TIERRA WEST, LLC

January 10, 2012

**RE: SPECTRUM ASSISTED LIVING,
GRADING AND DRAINAGE PLAN (A12/D025)
COMMENT RESPONSE**

ENGINEER'S SEAL	SPECTRUM ASSISTED LIVING	DRAWN BY BJF
		DATE 1/20/12
		2011026-C3A-GRB-30
RONALD R. BOHANNAN P.E. #7868	 <i>TERRA WEST, LLC</i> 5571 MIDWAY PARK PLACE NE ALBUQUERQUE, NM 87109 (505) 858-3100 www.tierrawestllc.com	SHEET # C3A
		JOB # 2011026

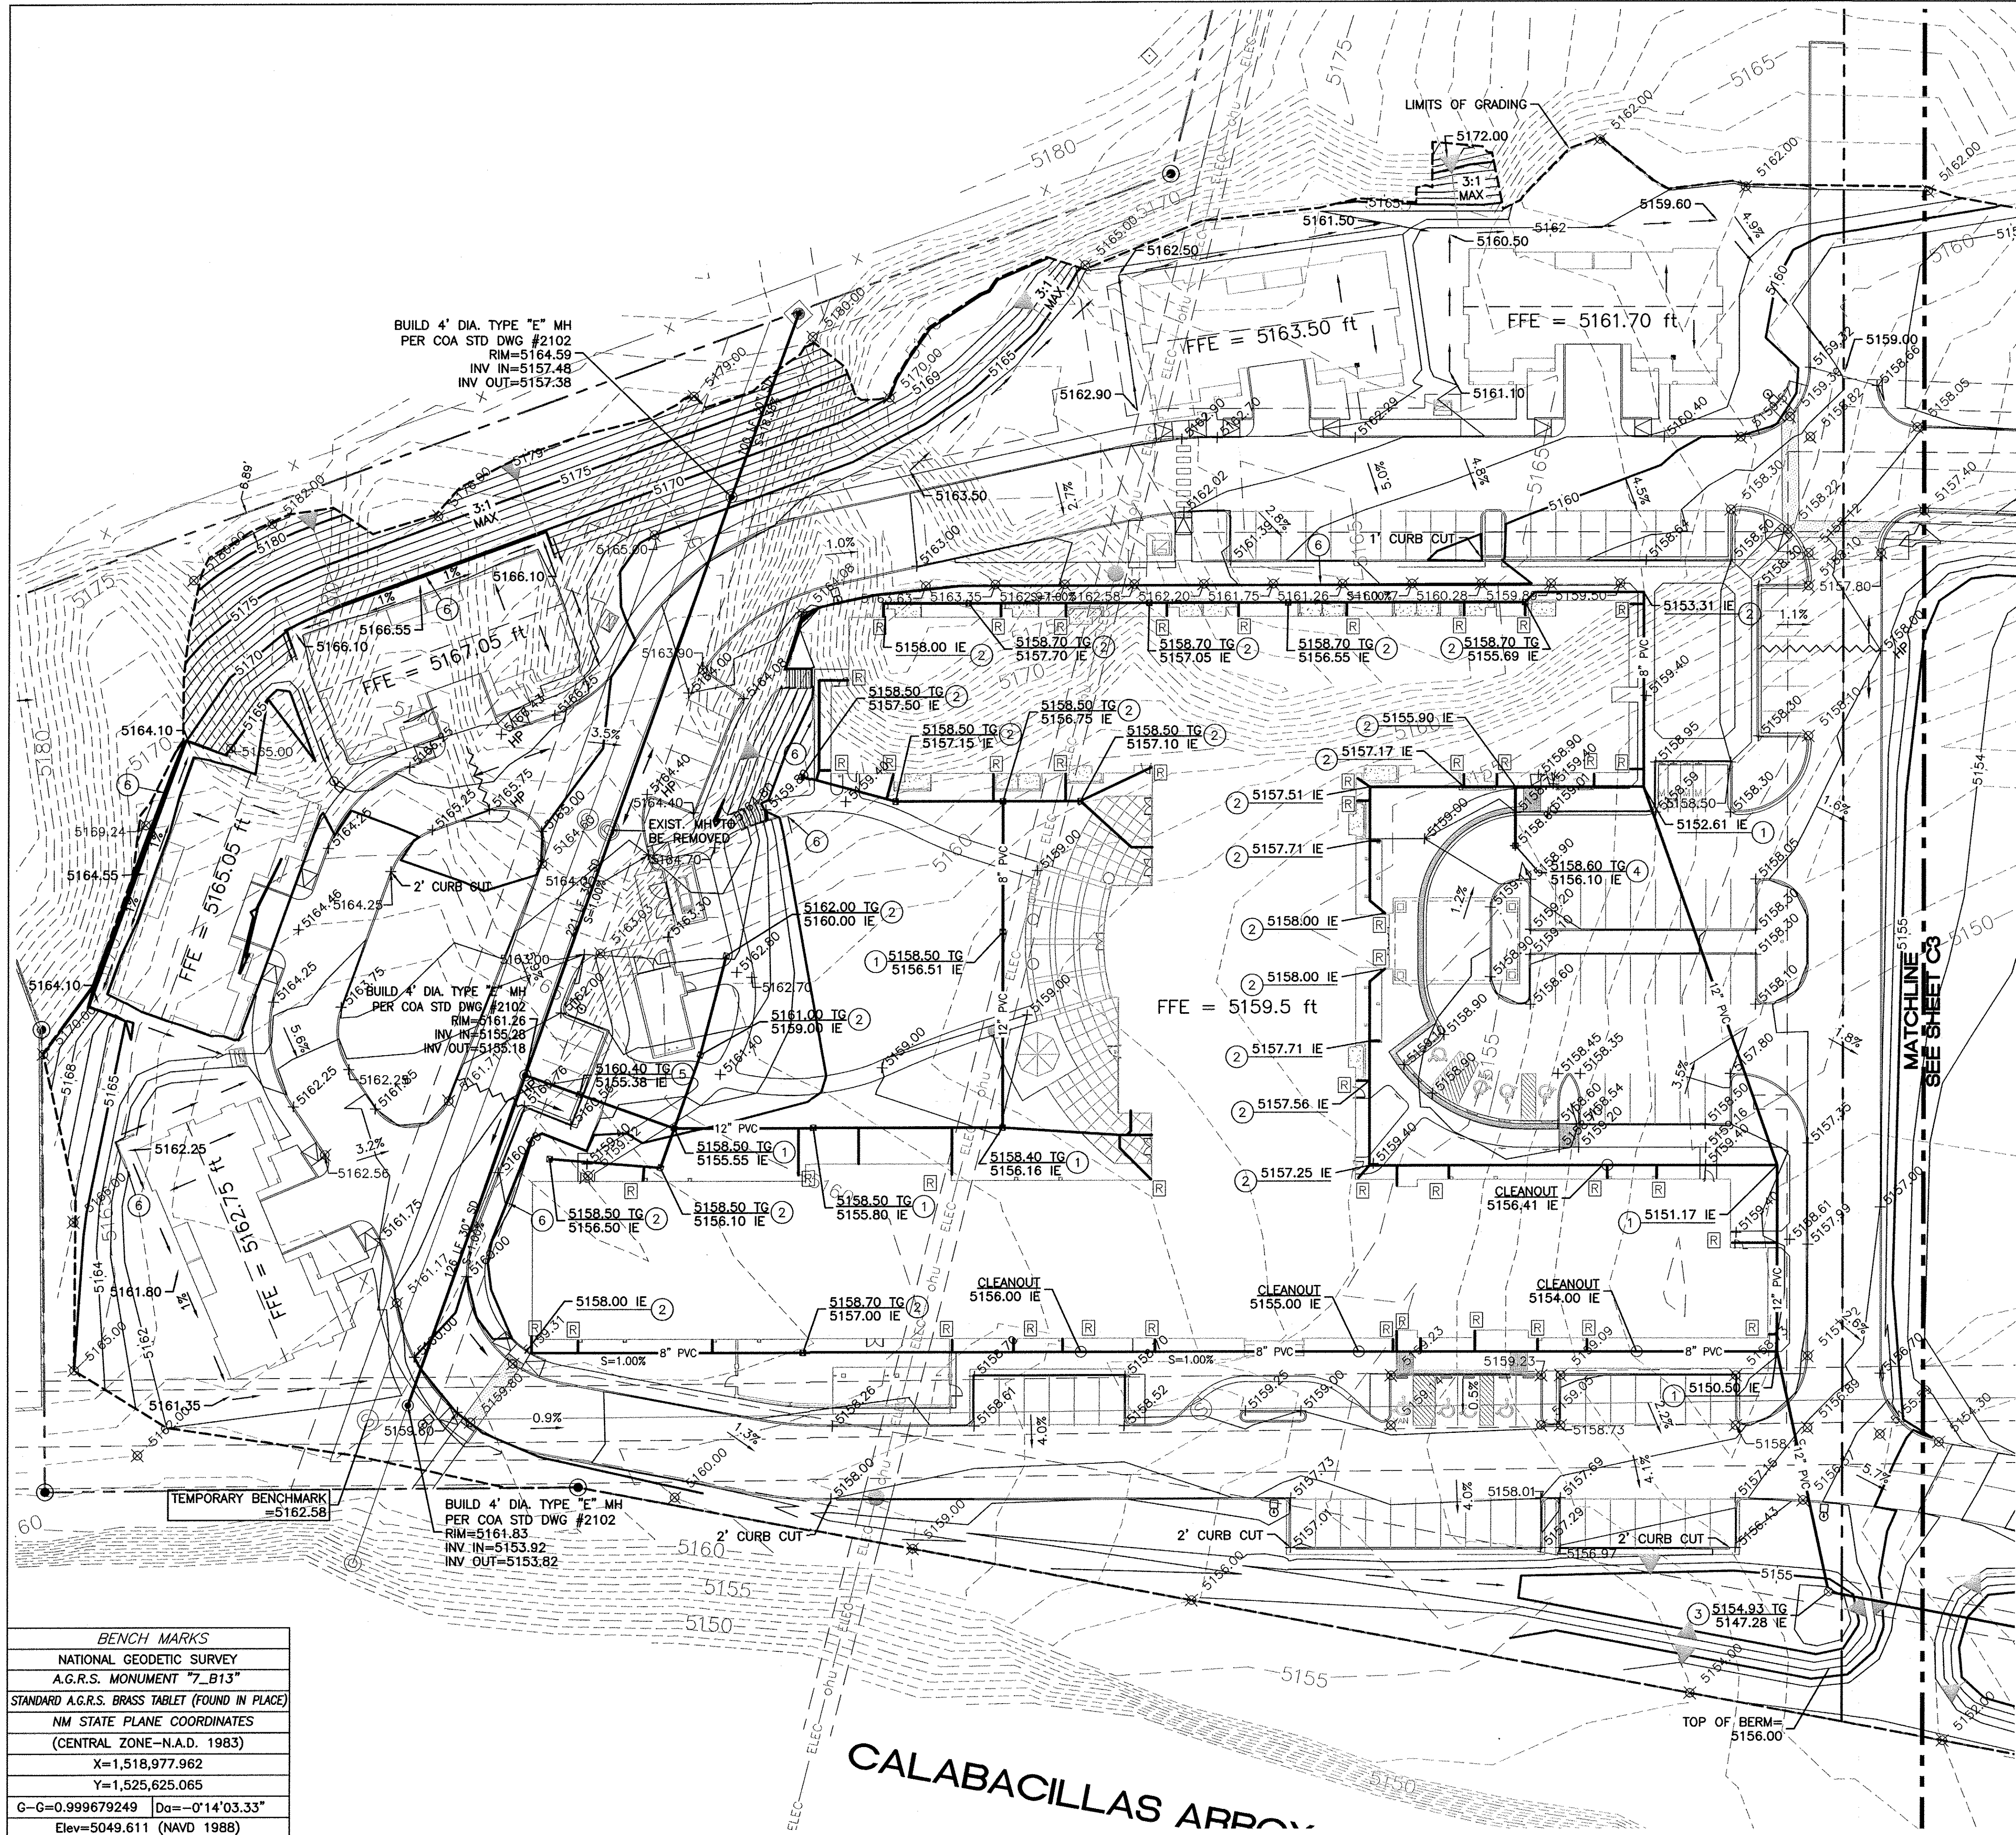
1. Provide existing spot elevations around the perimeter at regular intervals as well as inside to support existing contour data. ✓
We revised Sheets C3A and C3B to include existing spot elevations, as requested.

2. Provide existing contour data (legend?). ✓
We revised Sheets C3A and C3B to depict existing contour data per the legend and included additional contour labels.

4. Provide grades in west courtyard area of large building. ✓
We revised Sheets C3A to depict additional spot elevations, as requested.
5. Provide direction of roof flows, except the building with roof drains. ✓
We revised Sheets C3A to include direction of roof flows, as requested.

6. It is not evident that the area behind/along buildings will drain. ✓
We revised Sheets C3A to include earthen swale location, flow direction, and flow-line elevations.

7. Show high points/basin divides with spot elevations. *maybe OK*
We revised Sheets C3A and C3B to depict intermediate high points and flow directions at basin divides corresponding to the drainage report basin map.

8. To accomplish stormwater quality and to prevent inlets from being buried, the inlets in the water harvesting ponds along the arroyo should be elevated above pond bottom. How high should they be elevated to accomplish these goals? ✓

10. Hydrology could not find the benchmark information.

11. The flow line elevation at the north entrance is covered with text.

12. The slope near building FF 5 176 1.7 and FF=5 163.5 appear to be steeper than 3:1.

13. Steep slopes near the property line could affect neighboring properties. Provide proposed spot elevations at the top and toe. Will these areas be revegetated?

The inlets in the water harvesting ponds should be elevated by a minimum of 1-foot to accomplish water quality goals. We revised Sheets C3A and C3B to include a detail.

We revised Sheets C3A and C3B to depict temporary benchmark information with a text box for clarity. *No designation NO*

All proposed grading was designed to be no steeper than 3:1. We revised Sheets C3A and C3B to depict additional spot elevations to clarify this issue. ✓

All proposed and existing slope areas will be re-vegetated per the landscape plan. We revised Sheets C3A and C3B to include existing spot elevations, as requested.

ENGINEER'S SEAL	SPECTRUM ASSISTED LIVING	DRAWN BY BJF
		GRADING AND DRAINAGE PLAN	DATE 1/20/12
			2011026-C3B-GRB-30-1072
		SHEET # C3B	JOB # 2011026

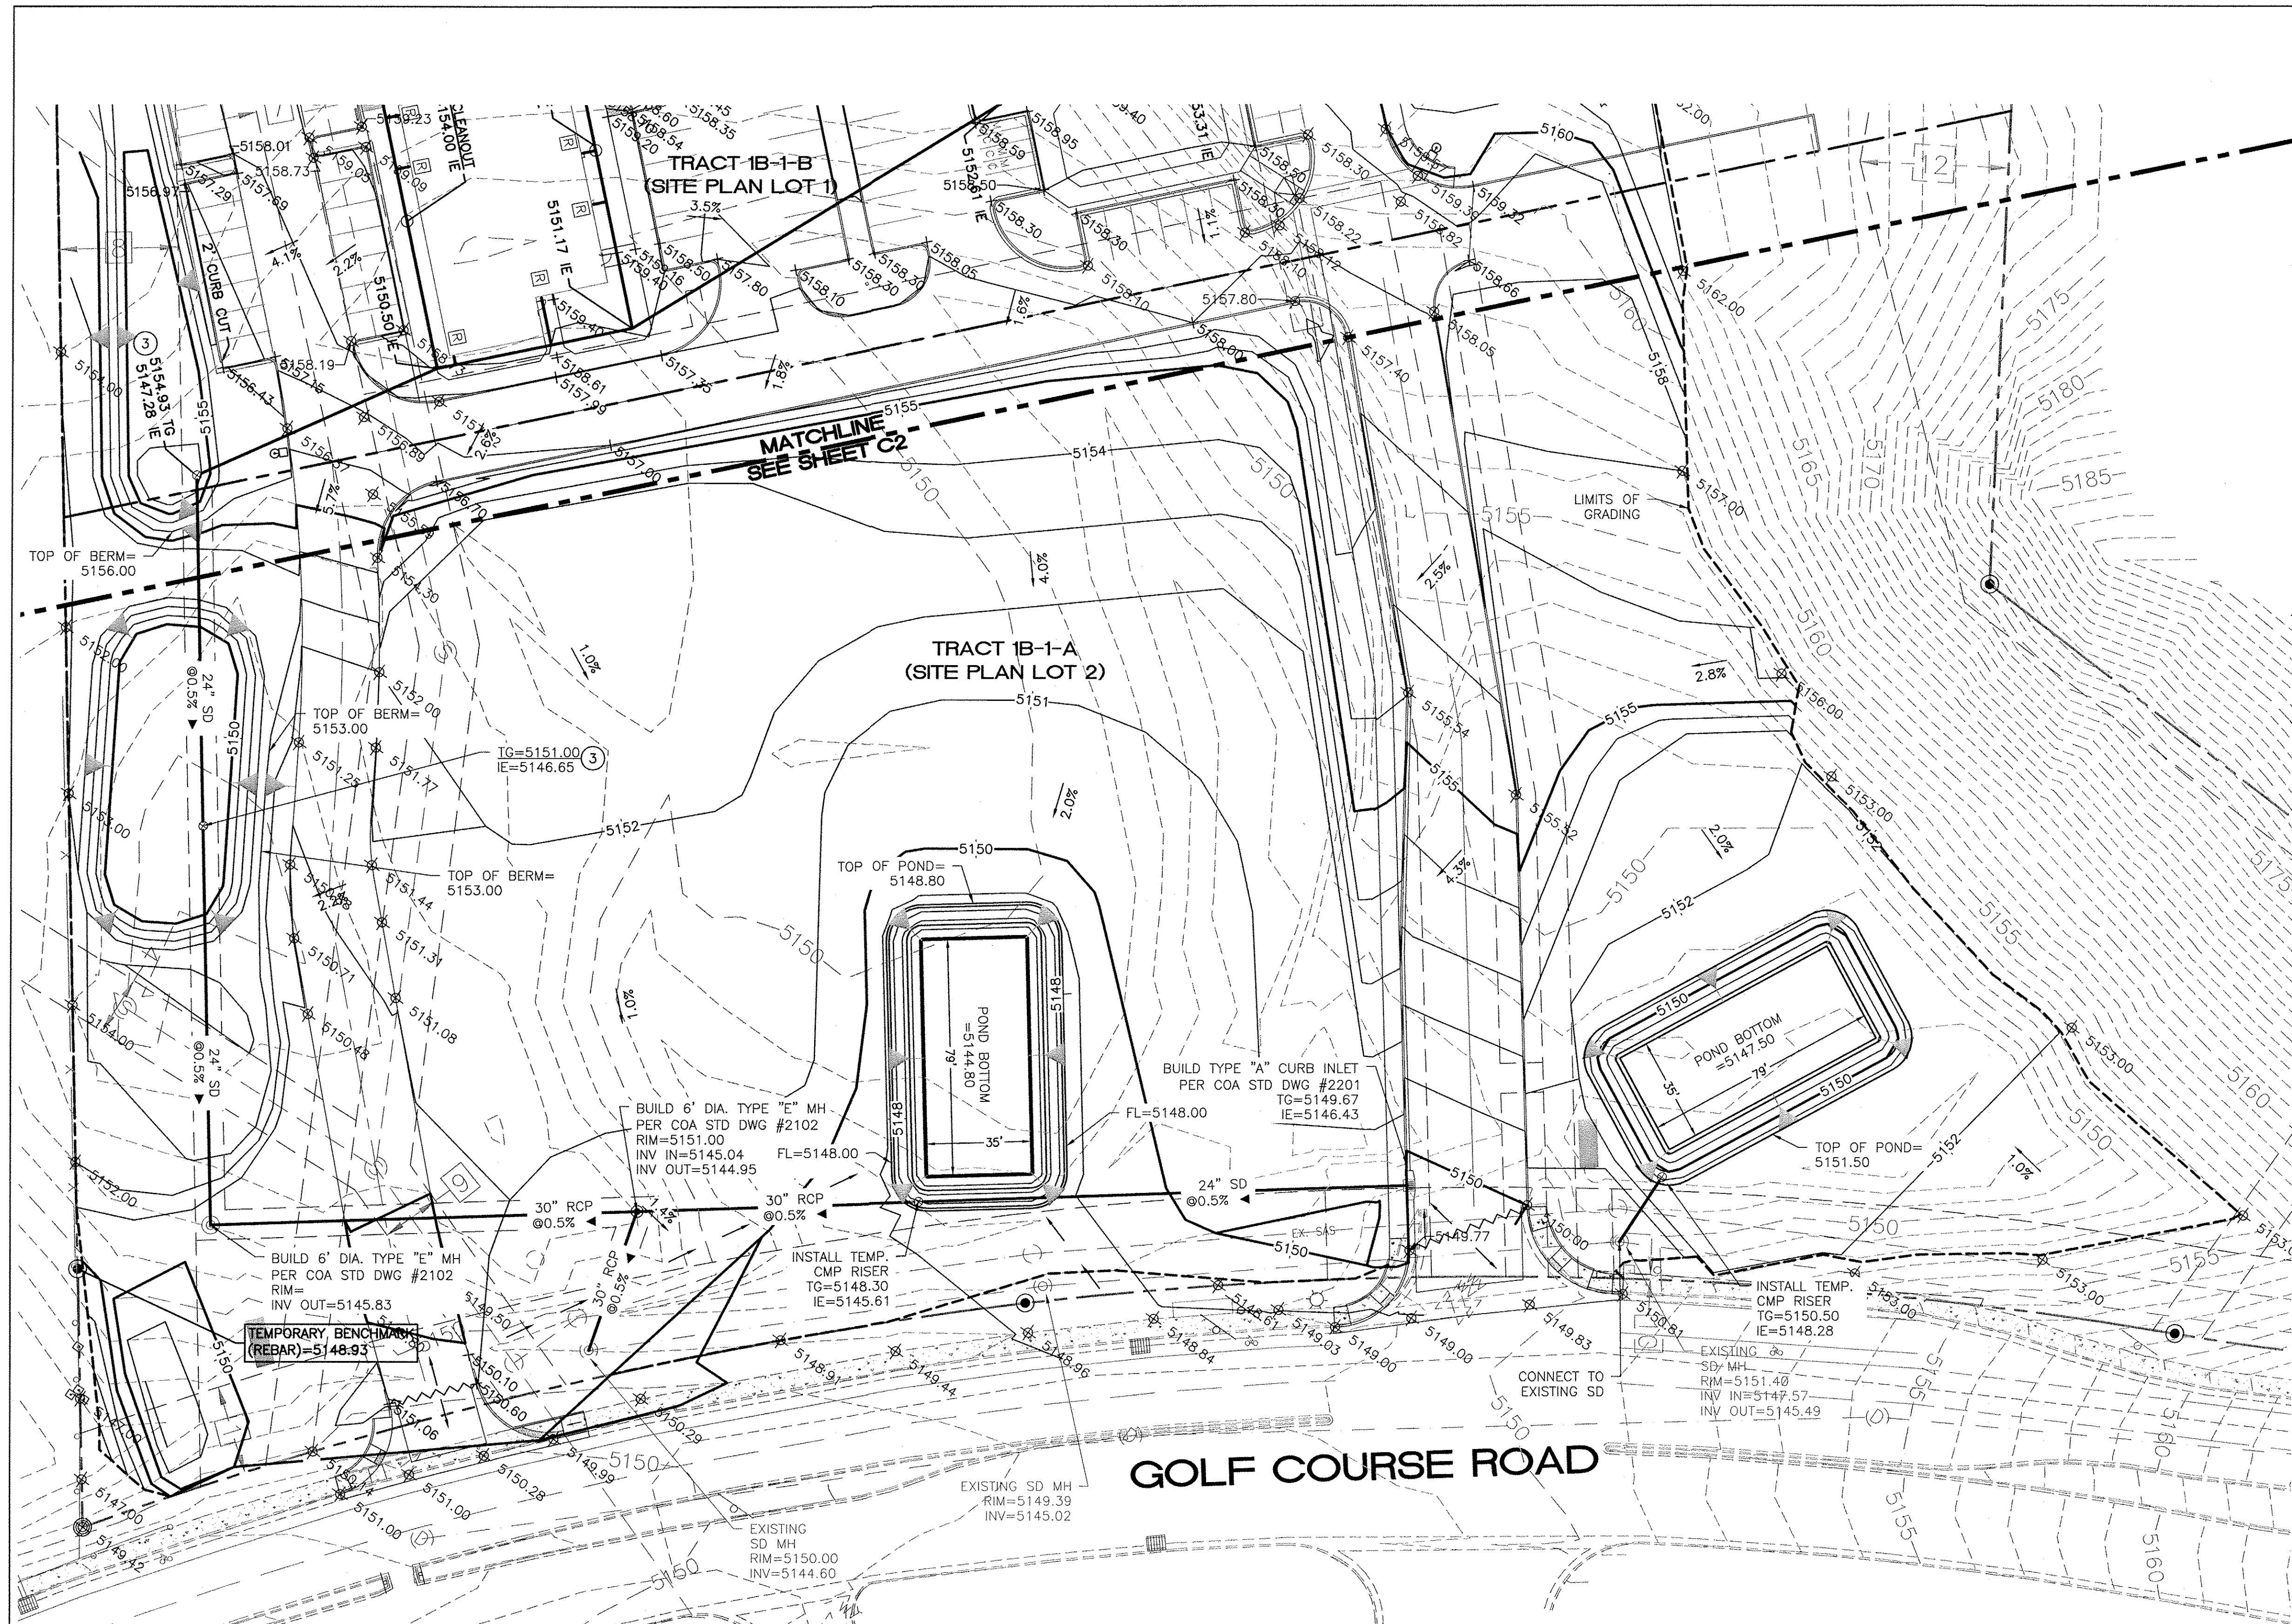
3. Provide numerous (similar to the top of sheet C3B) proposed spot elevations in the parking/drive areas as well as near the buildings.
We revised Sheets C3B to depict additional spot elevations, as requested.

9. Do the areas west of Golf Course Rd. drain to the sedimentation ponds? It is very difficult to tell in Basin 4. *Not working*

The areas west of Golf Course Road drain to the sedimentation ponds. We revised Sheet C3B to depict flow direction and additional elevation information.

We revised Sheet C3B clearly show the flow line elevation at the north entrance, as requested.
